Ribble Valley Borough Council

Date: 20th June 2025

Address: Lane Ends Farm Hothersall Lane Hothersall

Proposal: Proposed change of use of existing repair garage (Use Class B2) to incorporate MOT testing use (Sui Generis).

PROPOSED SITE PLAN

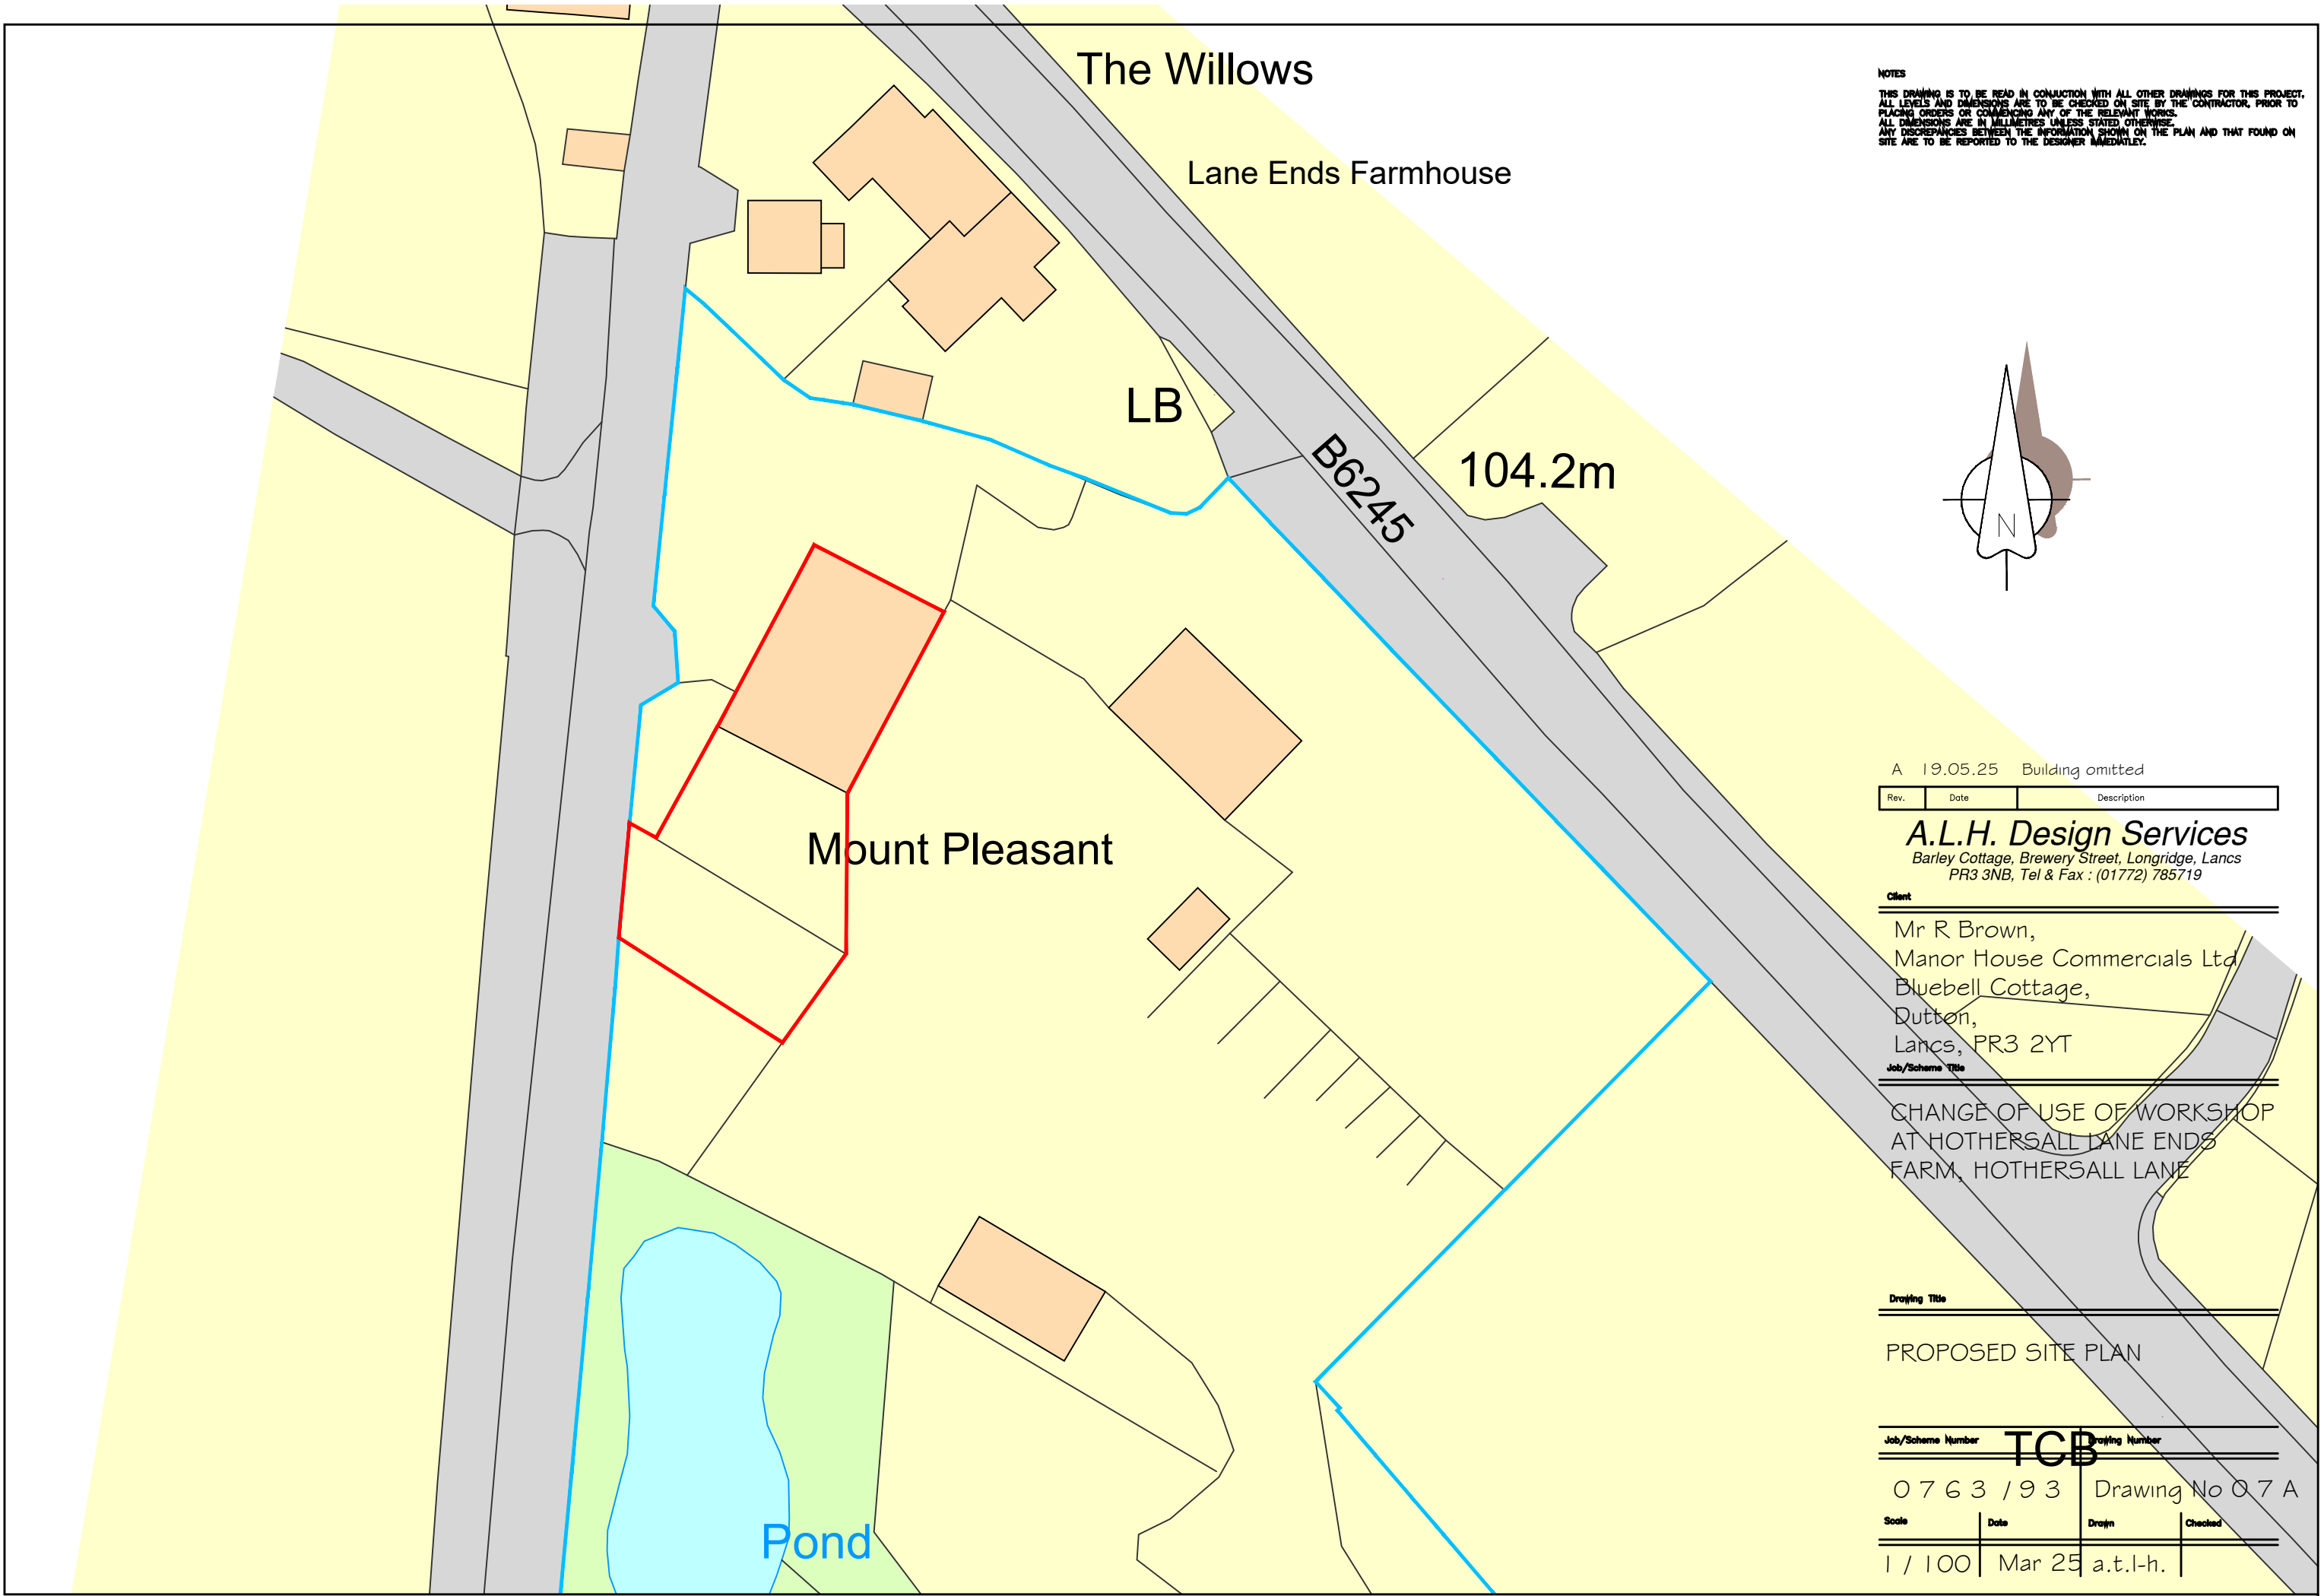
Secure, cycle parking should be provided for staff.

Due to the lack of footway on Hothersall Lane, the site would benefit from a pedestrian/cycle link to Preston Road which connects to the footway and the bus stops.

The parking standards for a vehicle repair centre is 1 space per 50sqm which equates to 4 spaces. There is sufficient space within the red edge for car parking to be provided. All vehicles must enter and leave Hothersall Lane in forward gear.
